# Steeple Renewables Project

**Applicant Response to Rule 17 Letter dated 02 April 2026**

Document Reference: EN010163/EX/8.60

Appendix 3: Humber Estuary SPA Focal Species Using Functionally Linked Land

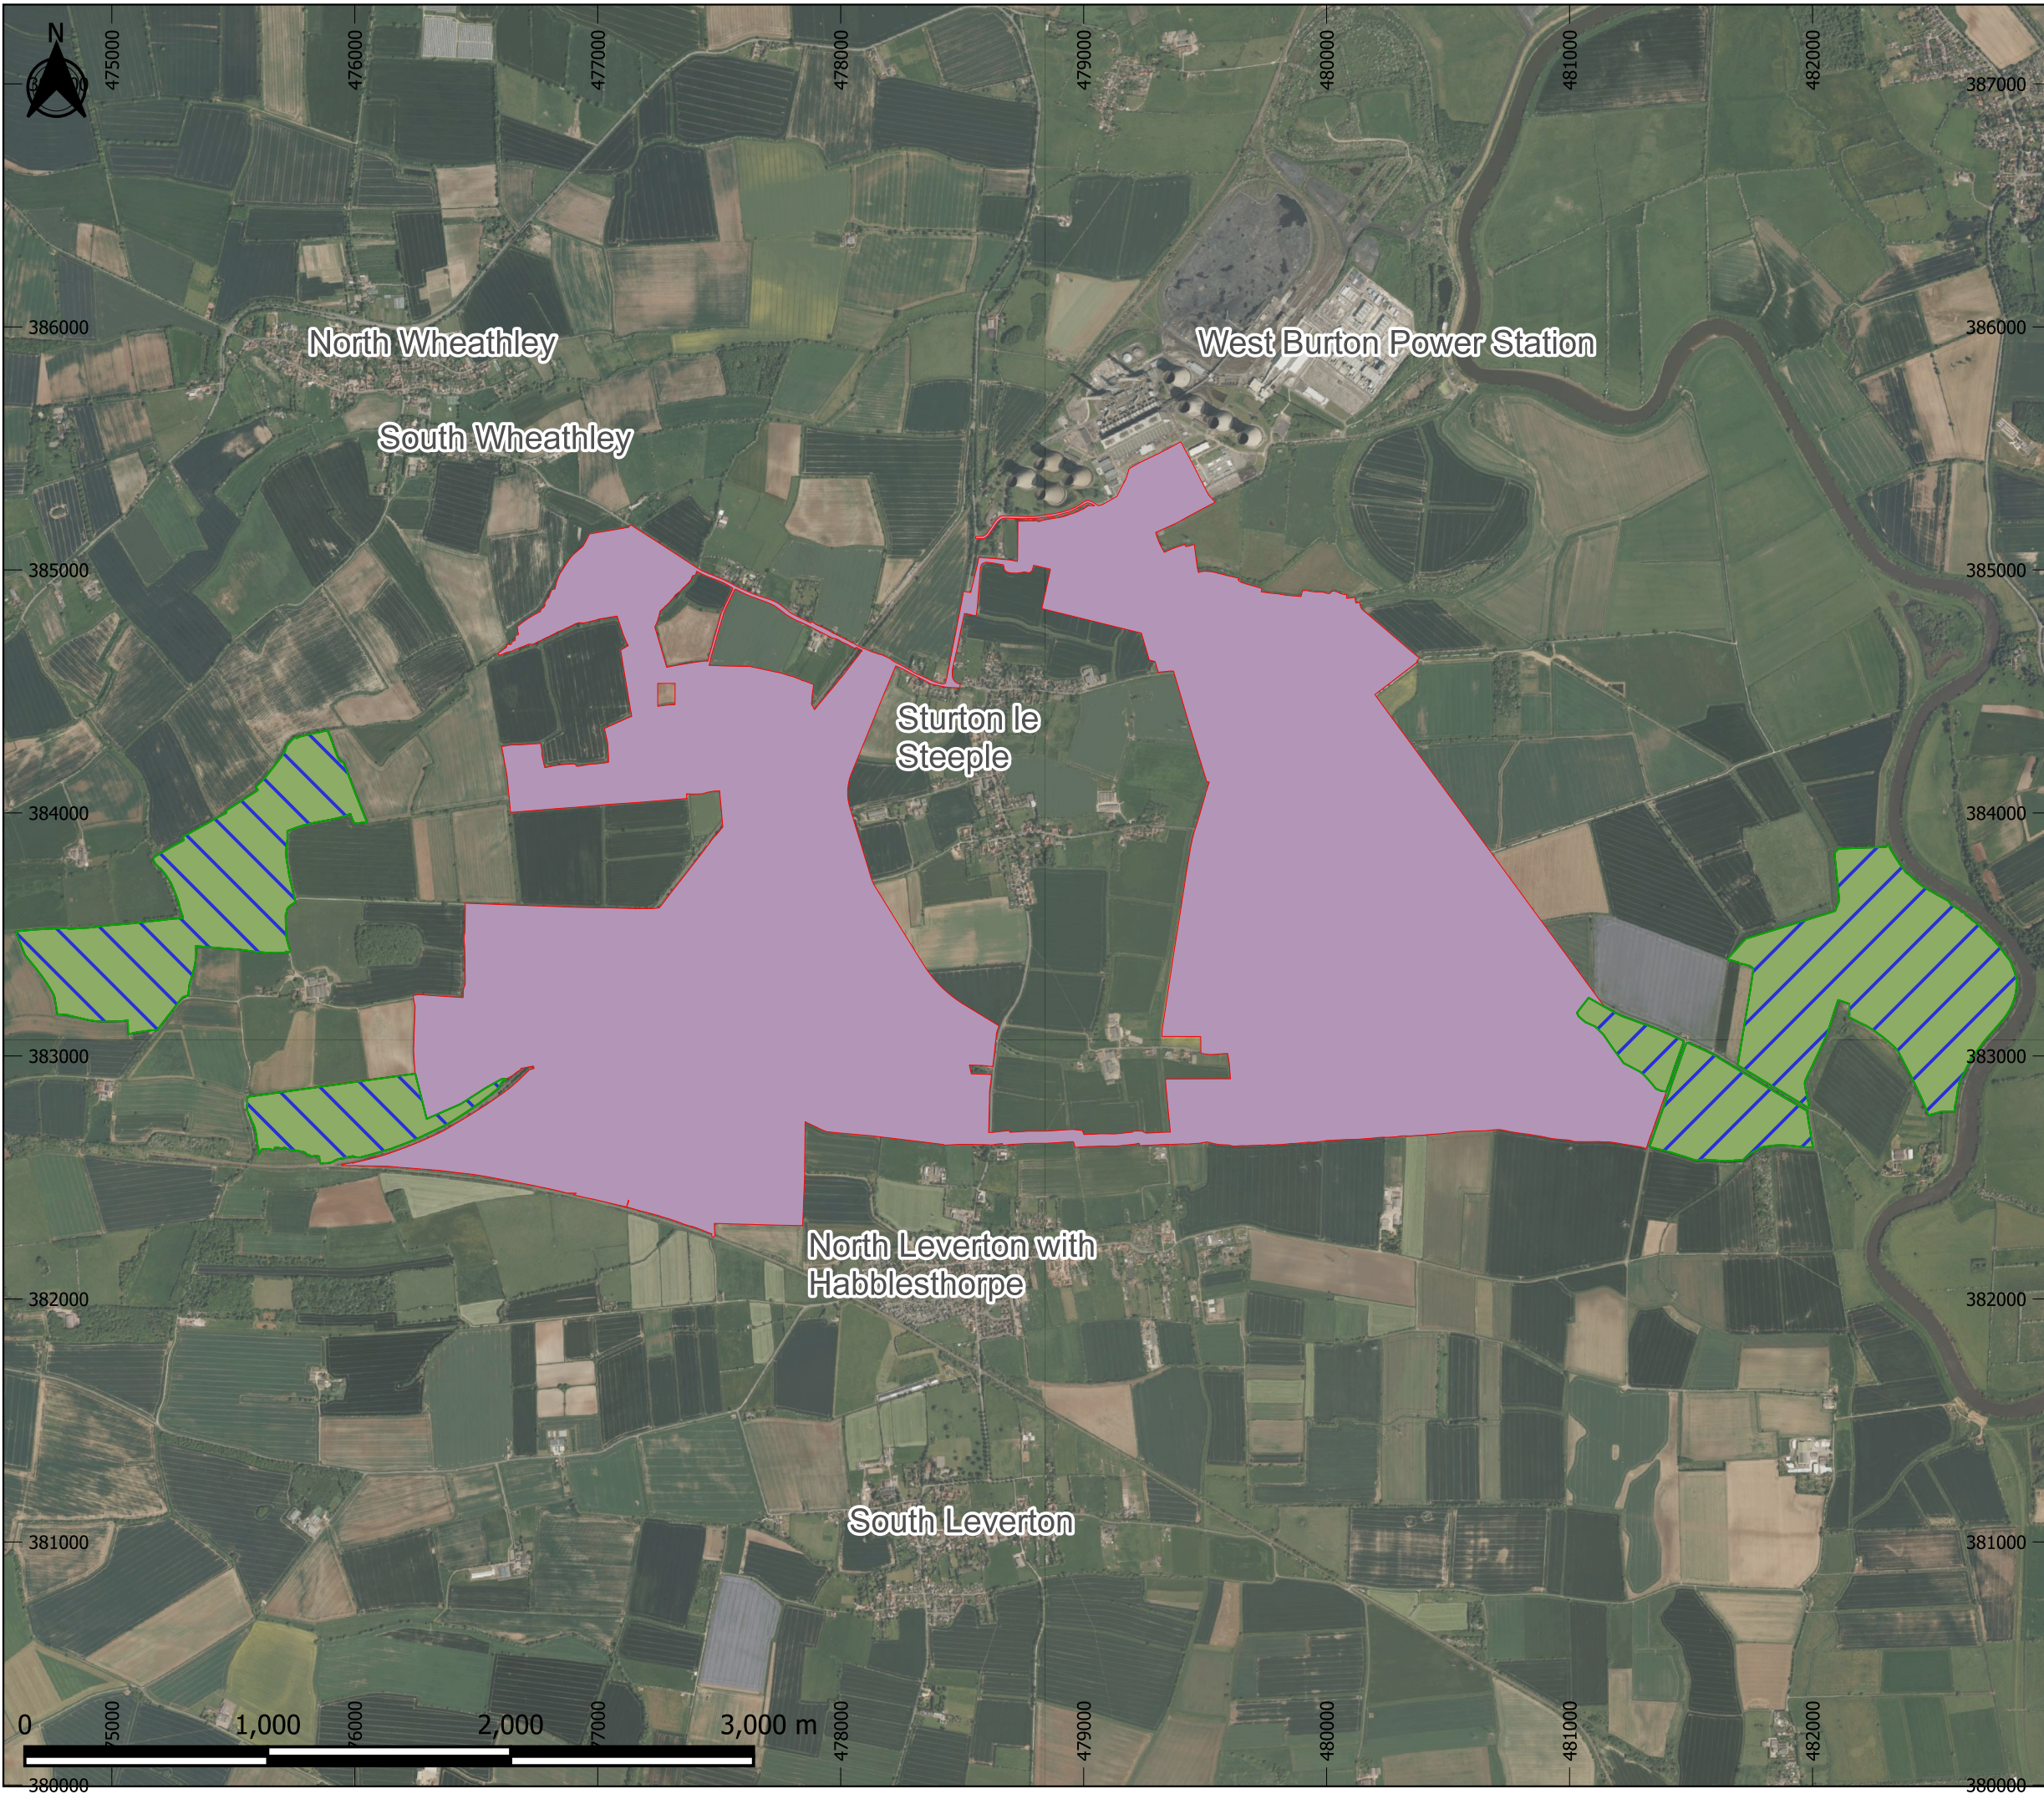
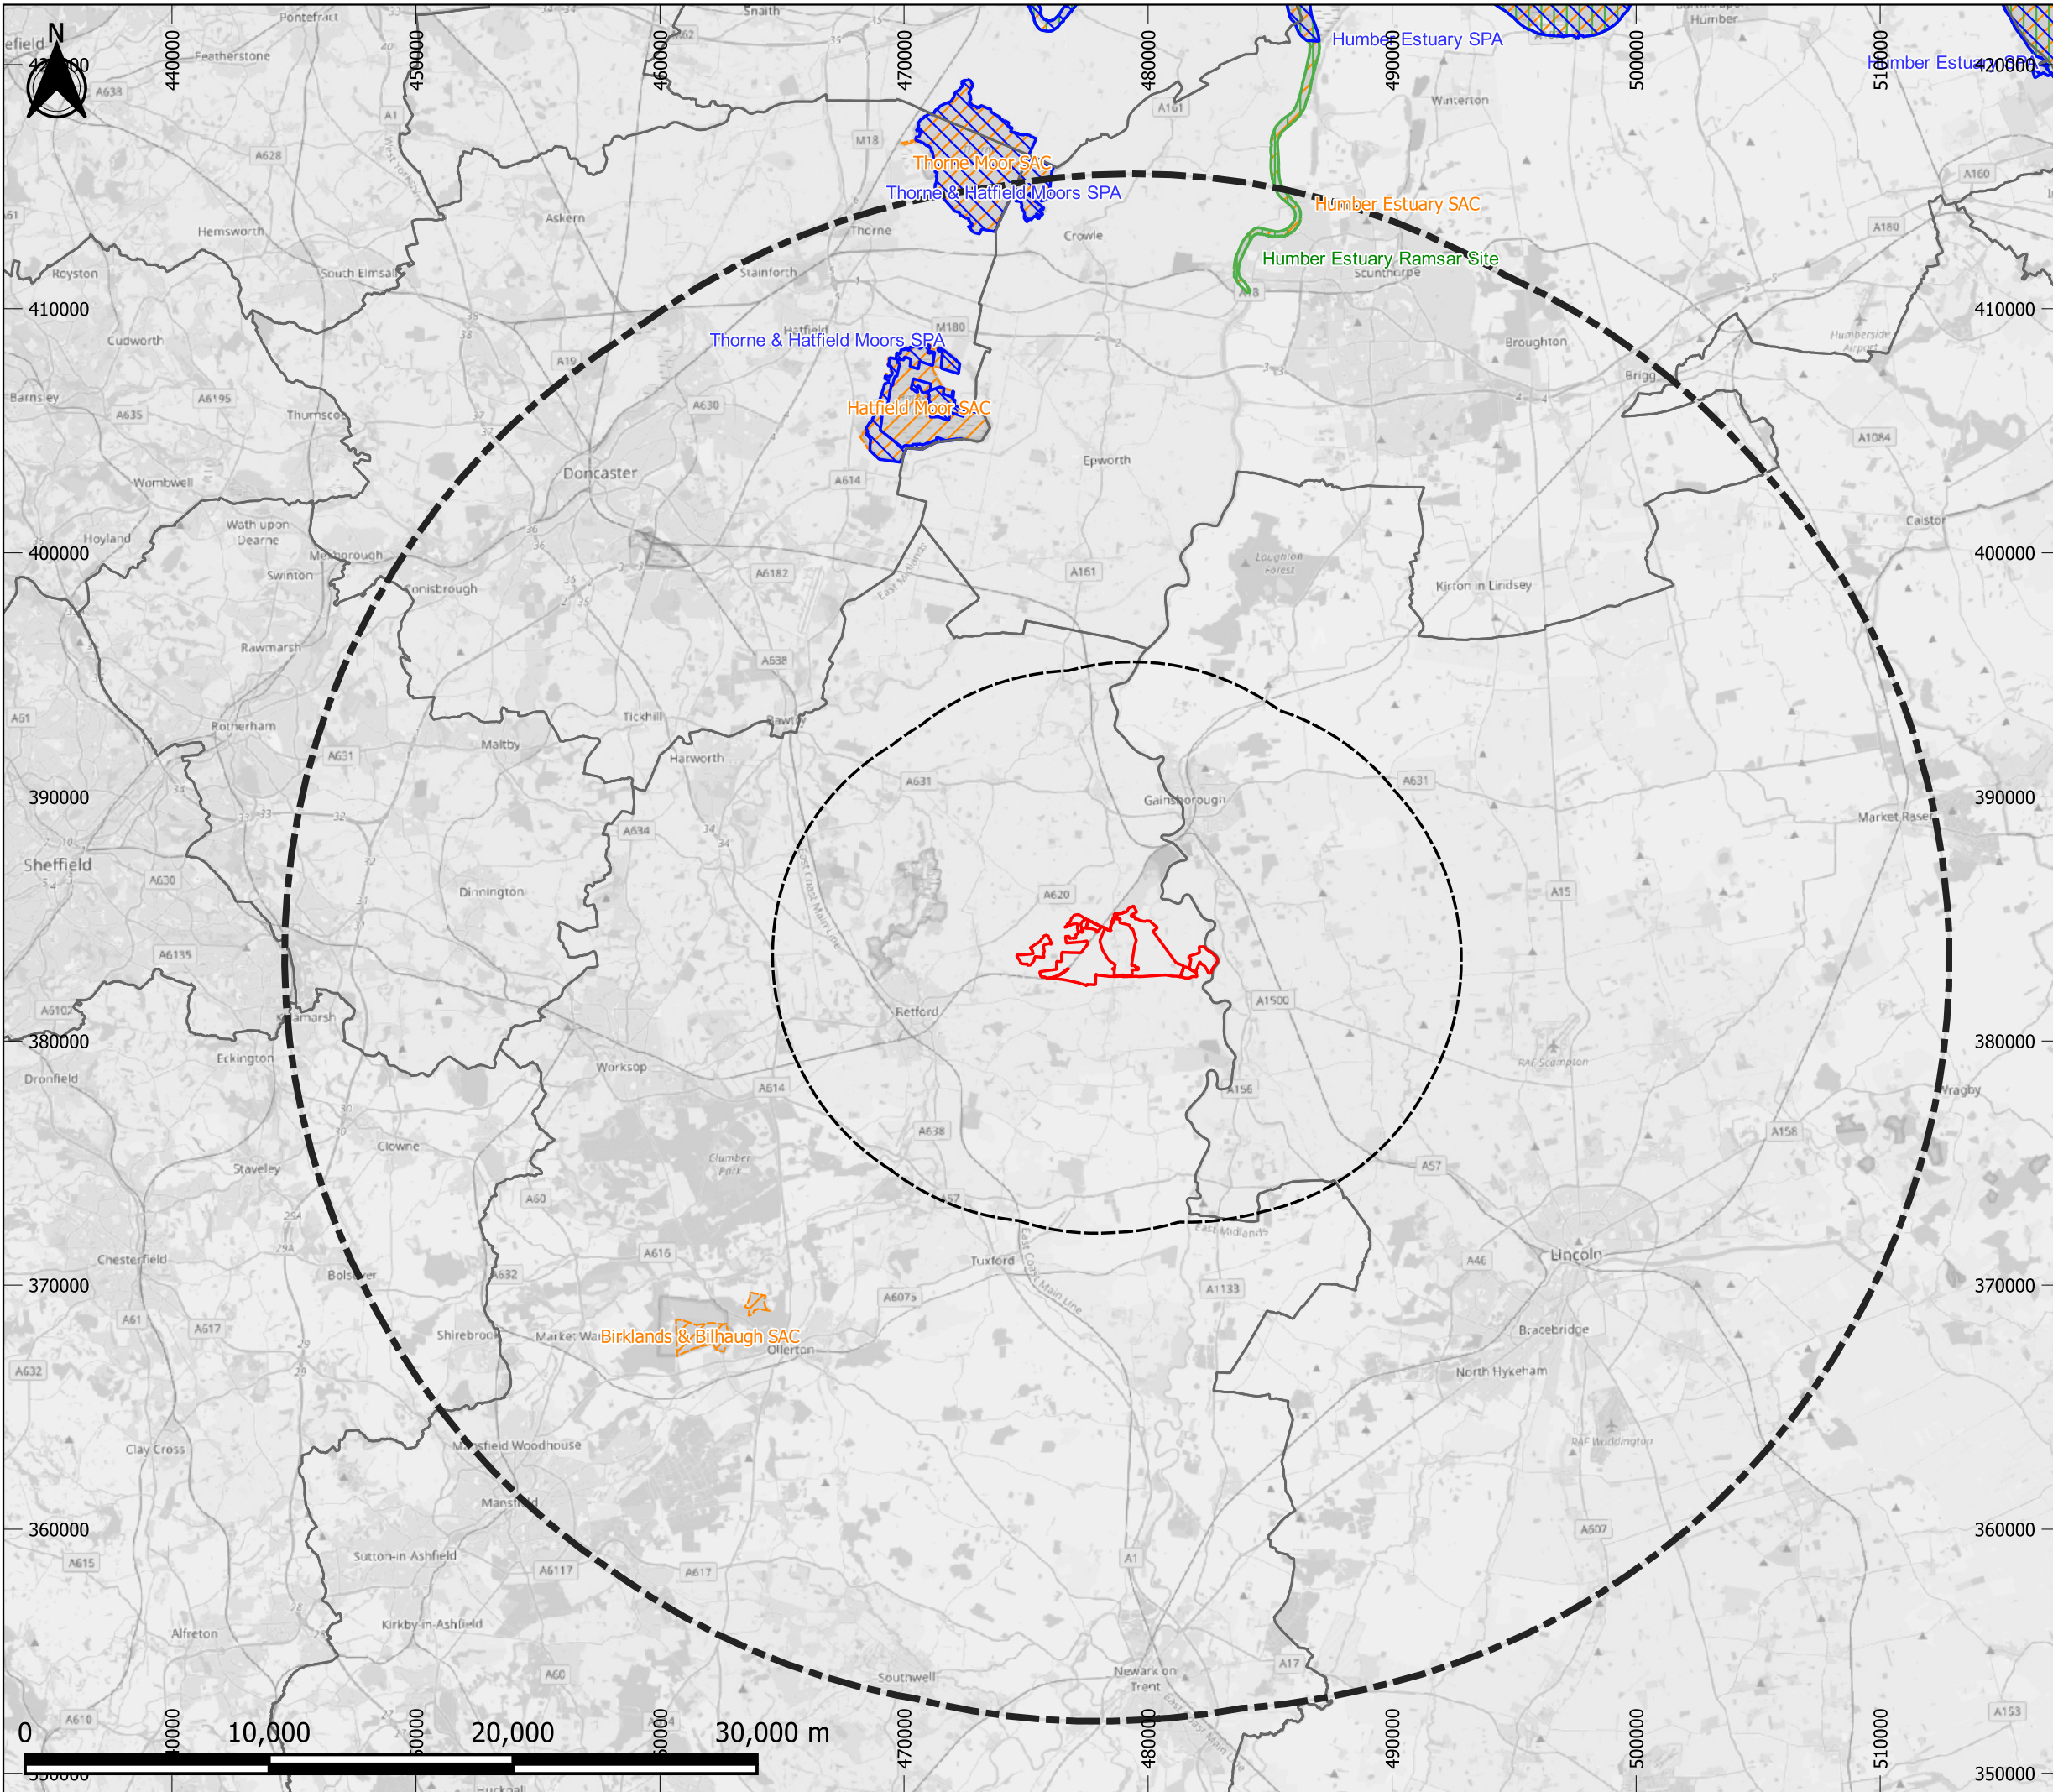
<p>PD-010/2</p>	<p><b>Habitat Regulation Assessment</b></p> <p><b>Applicant:</b> In response to the ExA’s second written questions (ExQ2) Q5.0.2, an updated version of the Information to inform a Habitats Regulations Assessment was submitted <b>[REP5-011]</b>. However, figures 1 and 2 are missing. Please resubmit with the figures included.</p>	<p>A revised Information to Inform Habitat Regulation Assessment (Document Reference EN010163/EX/5.5 Rev 3) has been submitted at Deadline 6 that includes figures 1 and 2.</p>
